Recommendation Report for Planning Permission for Works or Extension to a Dwelling

REF NO: AW/35/22/HH

LOCATION: 49 The Drive
Aldwick
PO21 4DS

PROPOSAL: Erection of single storey rear extension and conversion of loft to habitable use following the demolition of existing rear conservatory.

4 North (Rear) Elevation Proposed
1 : 100

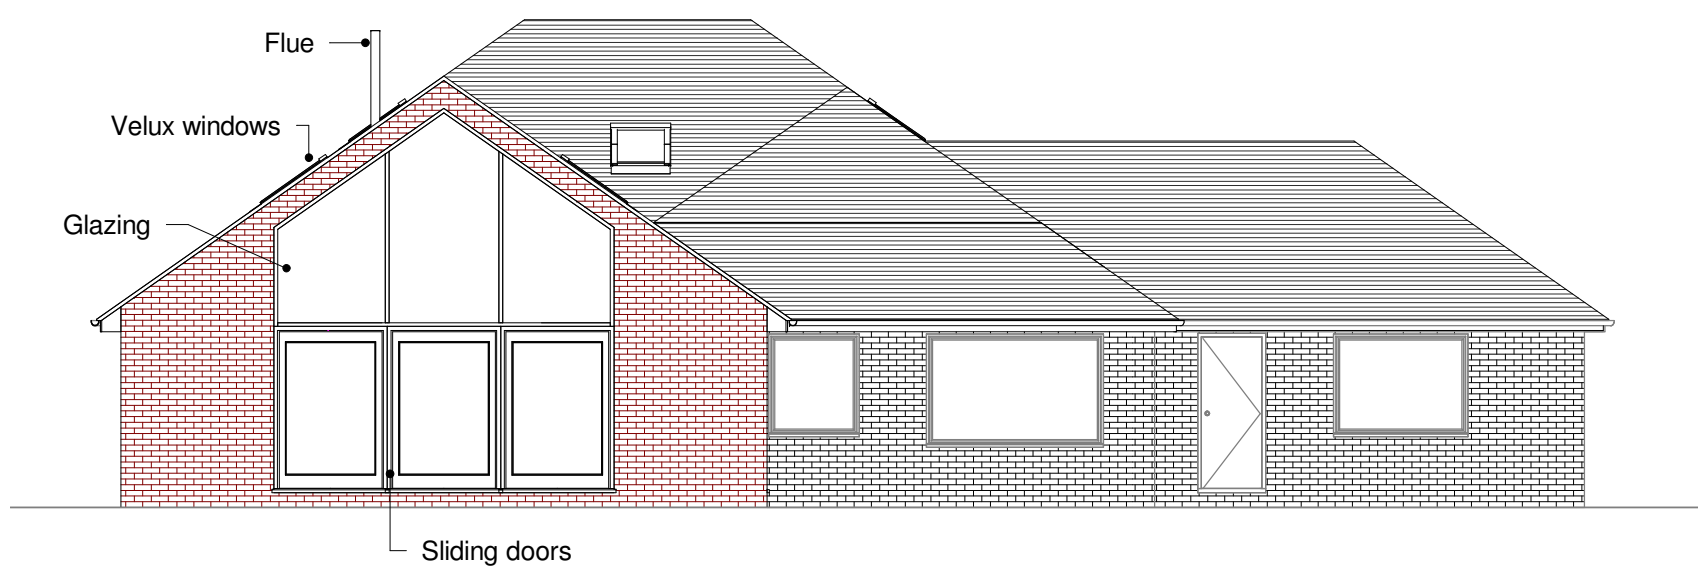
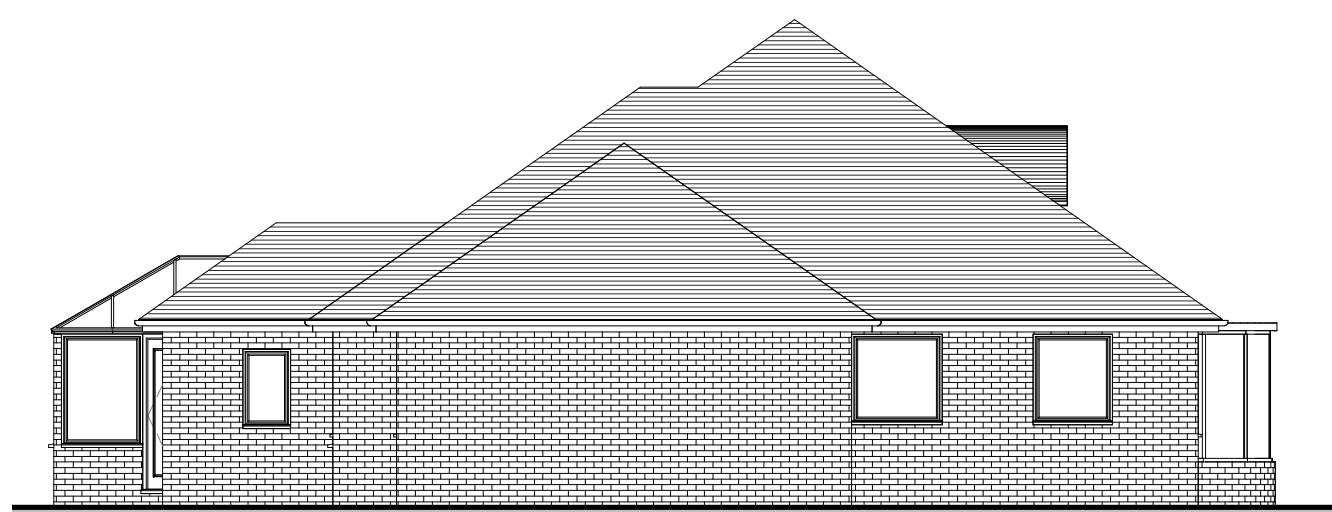
The rear elevation of the extension will feature glazing to the gable. With no first floor level in the extension there will be no views achievable at this height towards the properties to the rear. The loft will be converted for a habitable space although internally a wall will remain which restricts views from this bedroom through the first floor glazed element. A condition will be included to ensure this is kept in place and should any change in the future be intended this can be assessed through an application.

8 East (Side) Elevation Proposed
1 : 100

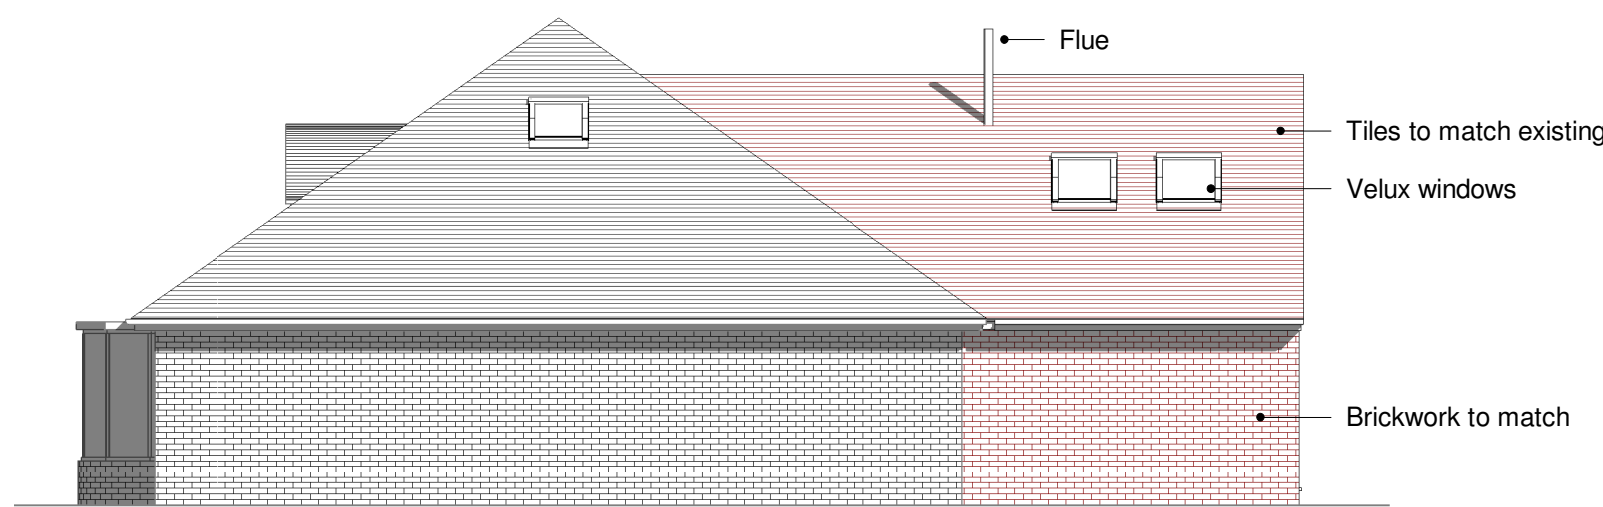
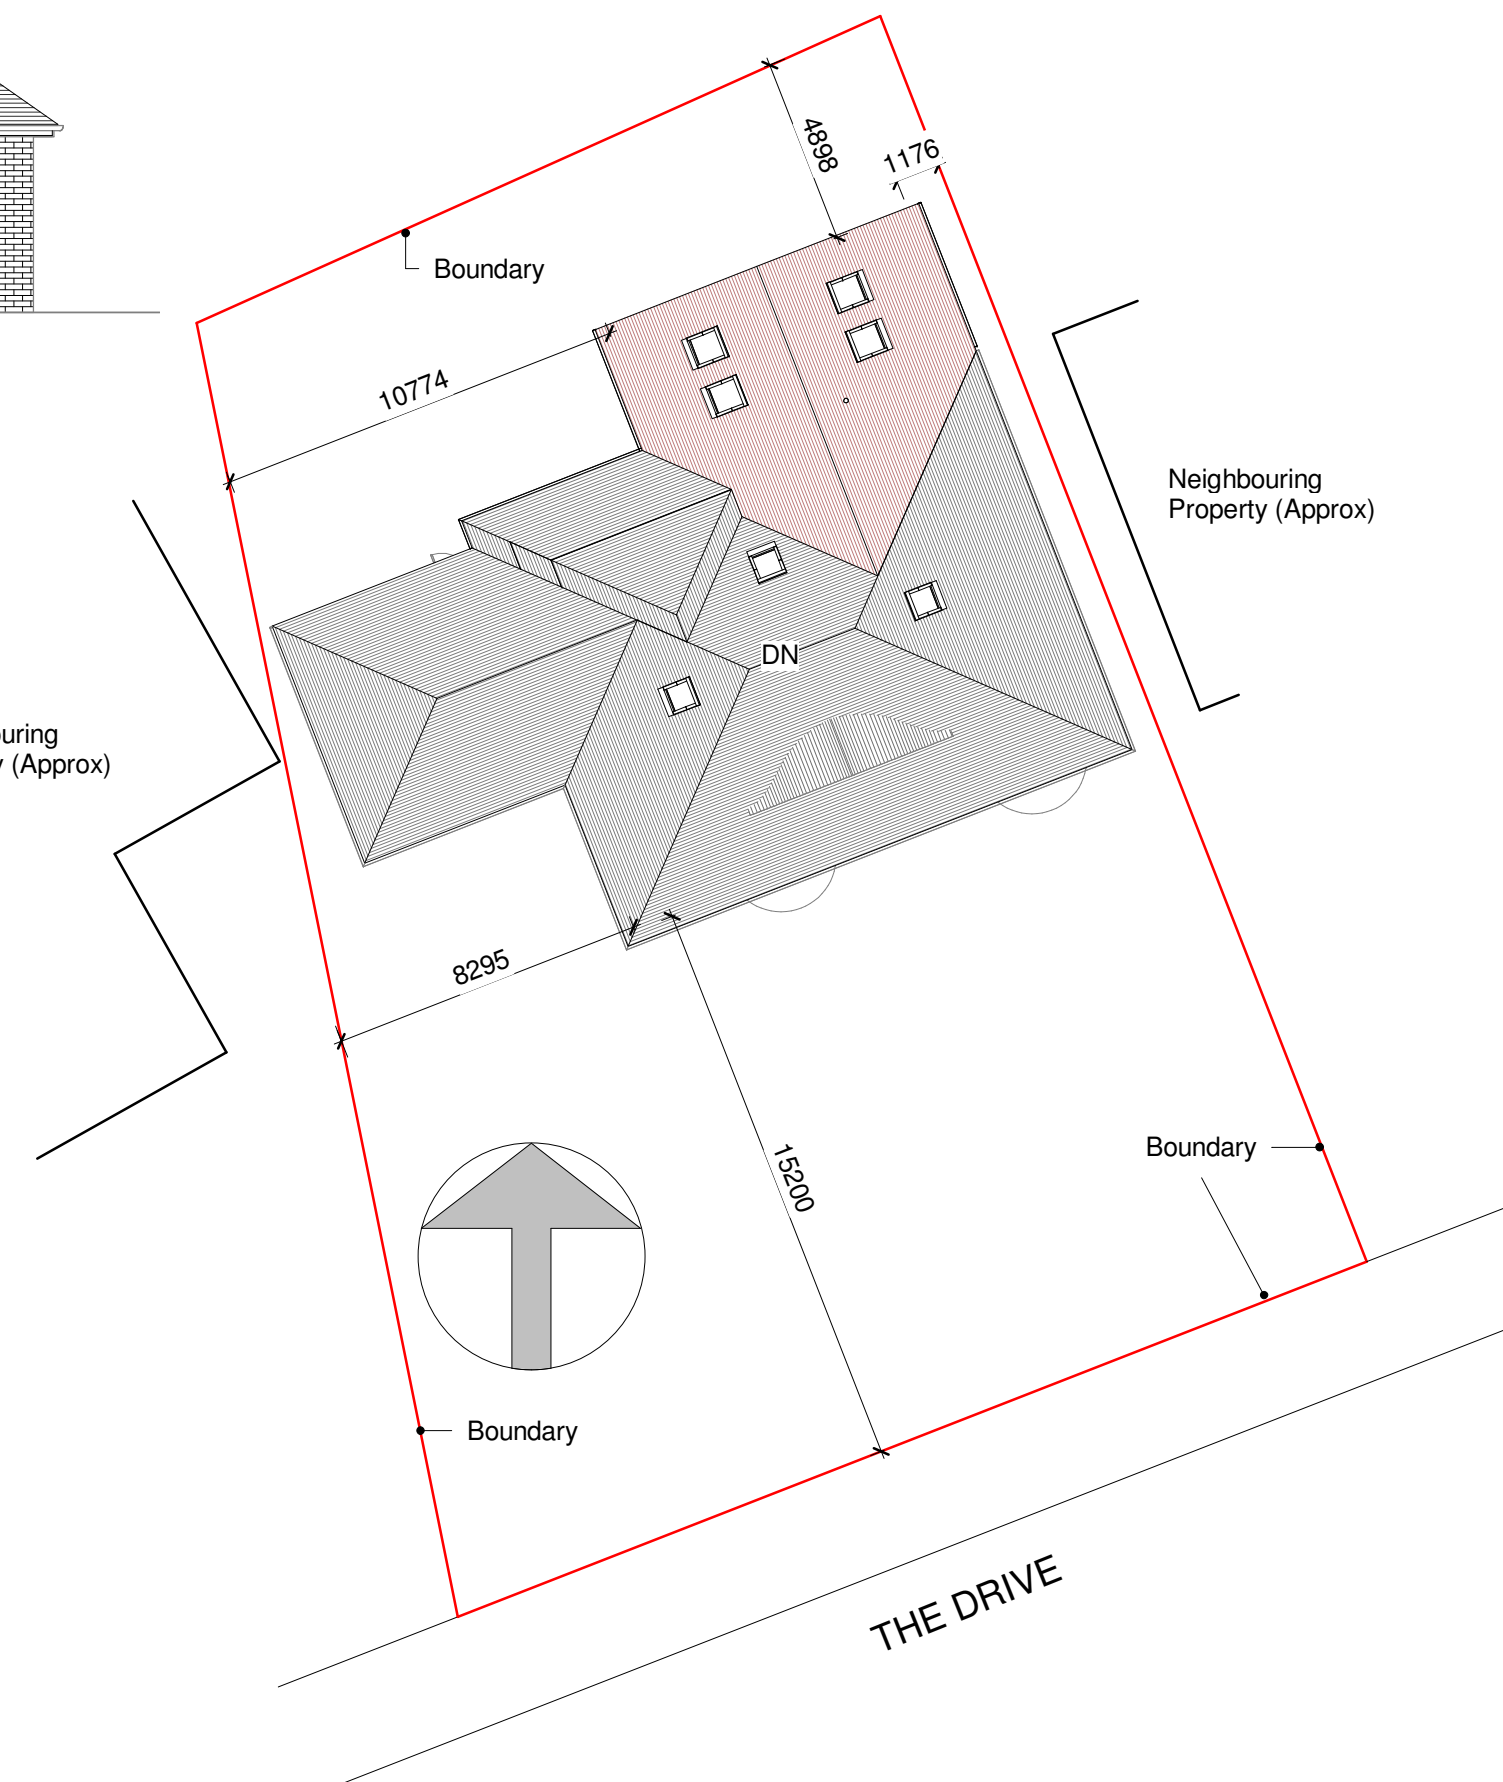
The extension is tall and with a gable end roof, it will result in some overbearing and being located to the east, will also result in some overshadowing on the neighbour at No.51. This is not significant, with the depth of the extension not increasing from that which is already there and it does not intersect a 45 degree angle from the window closest to the boundary.

Ground Floor
Plans

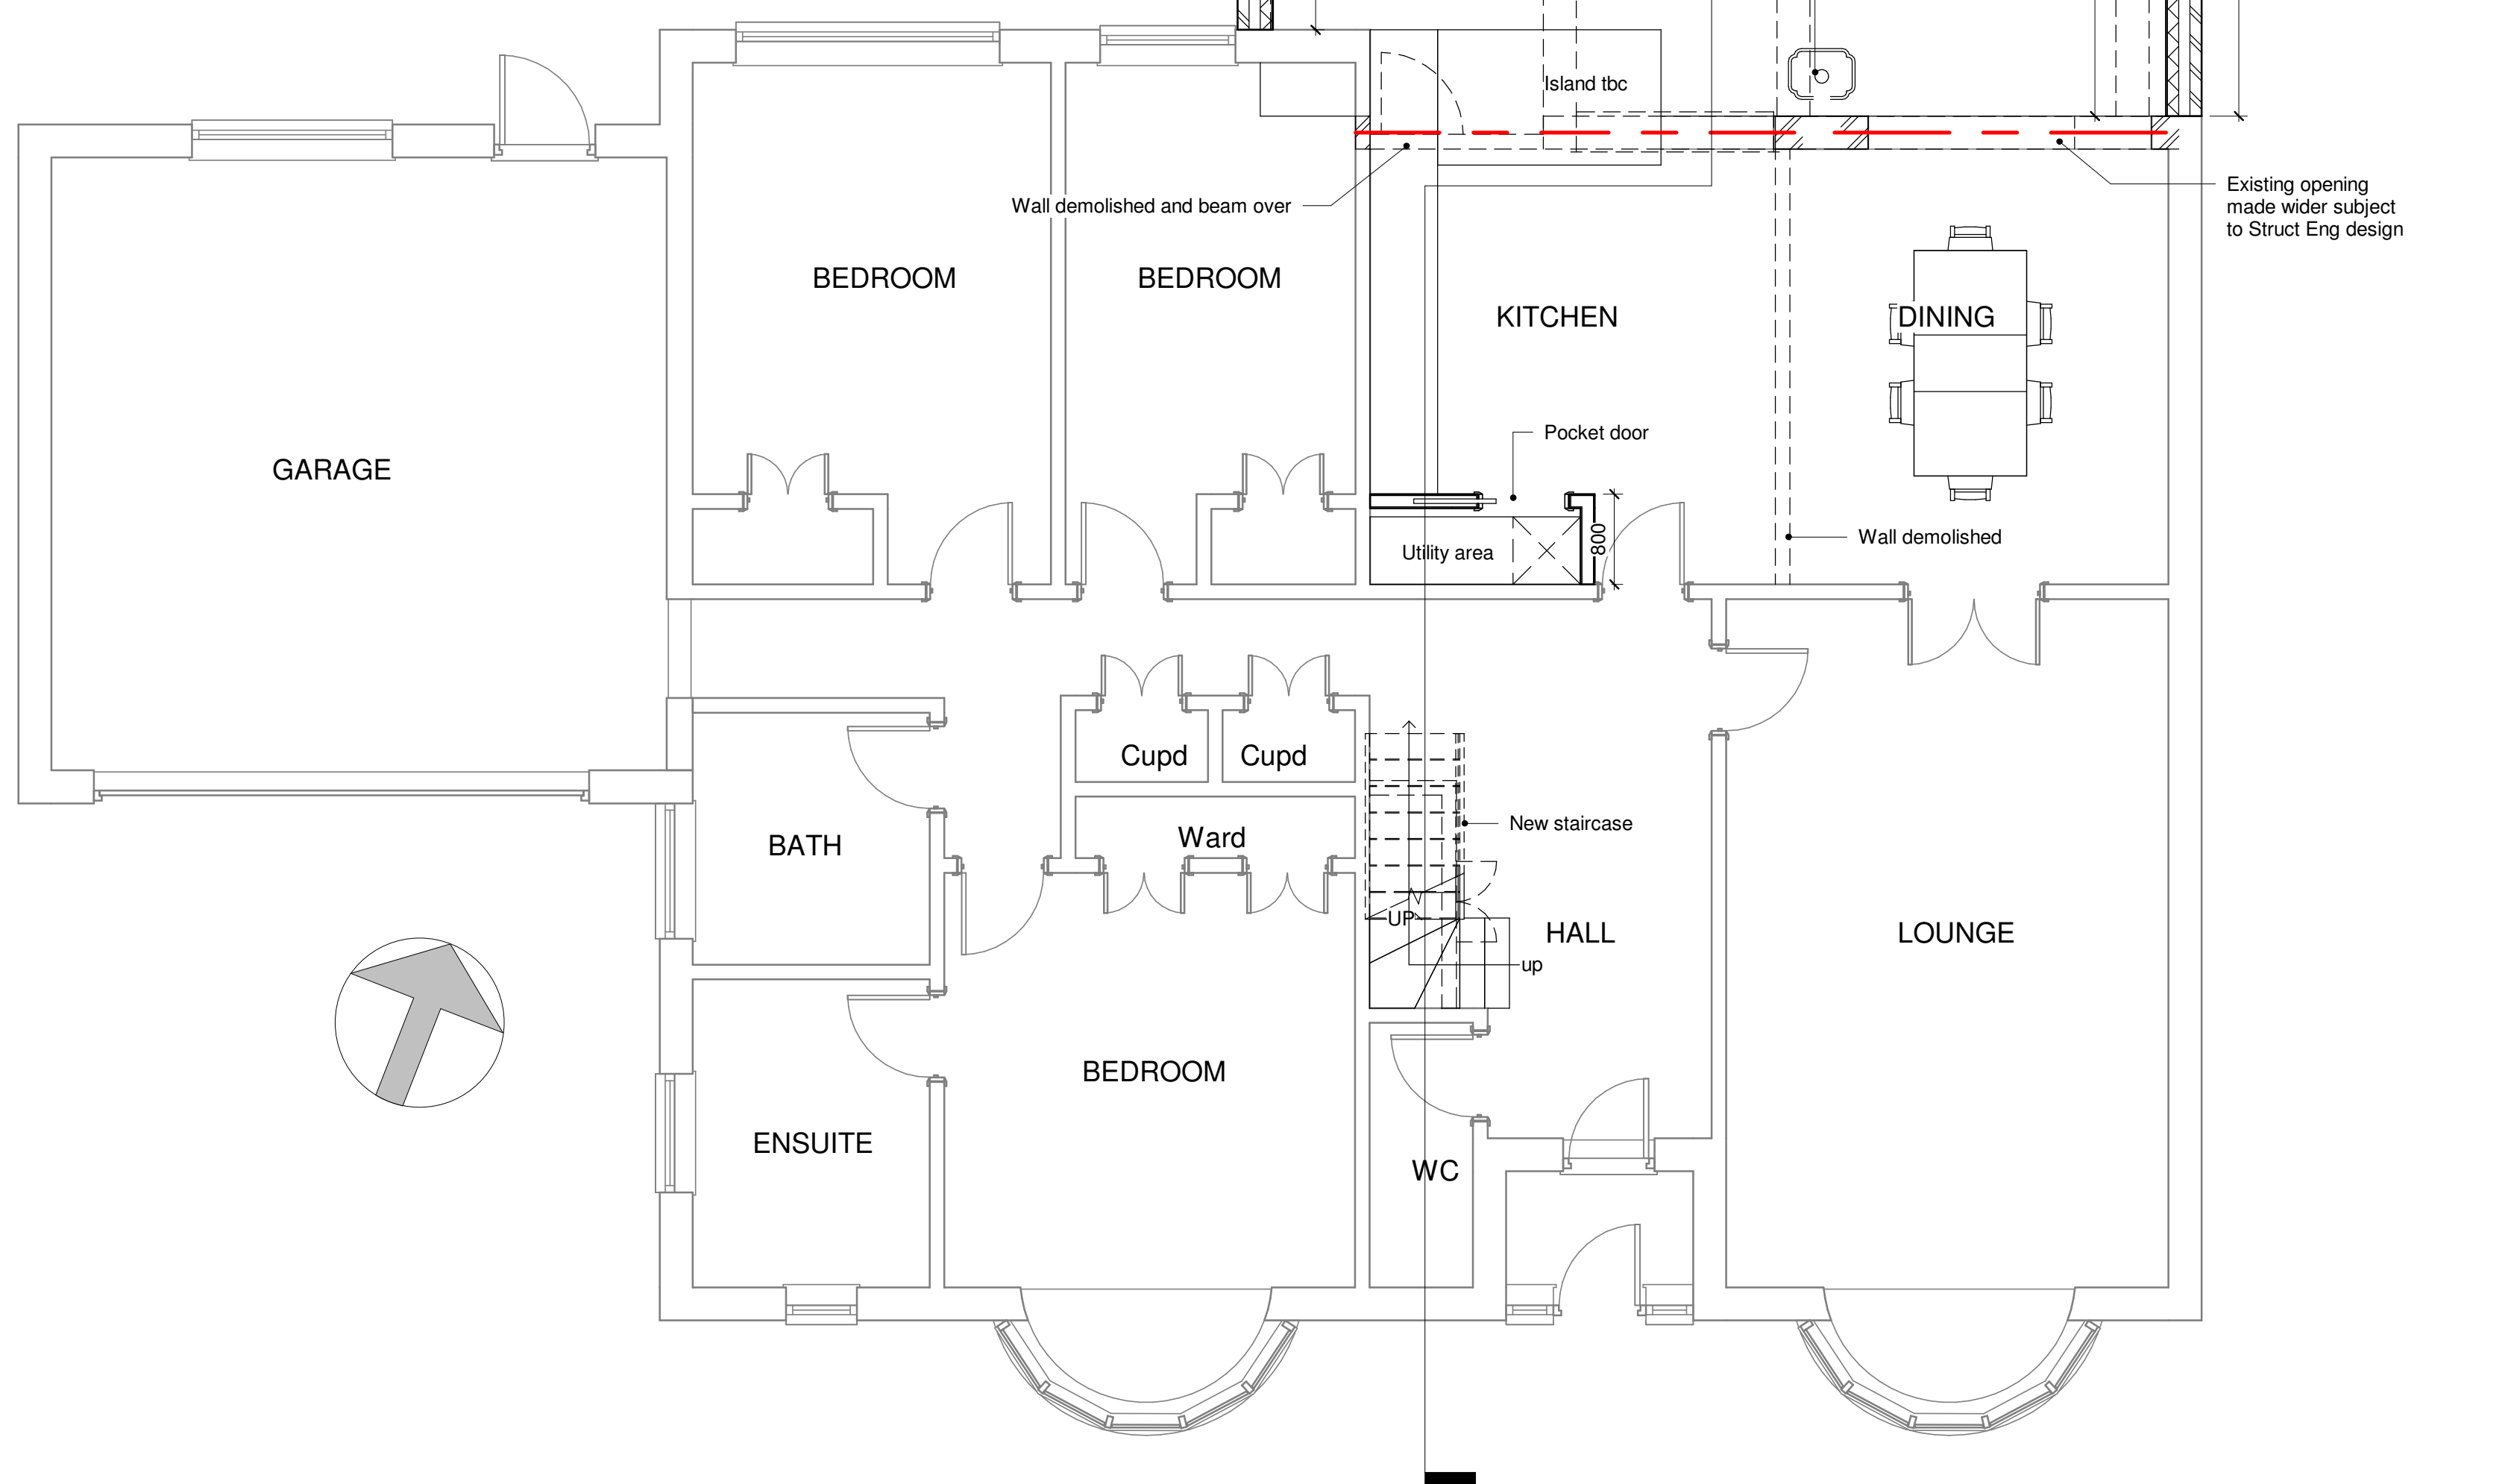
There is a conservatory which will be removed and replaced with an extension with a depth of 4.4m. This will increase in width and will incorporate a utility room and run along approximately half of the rear
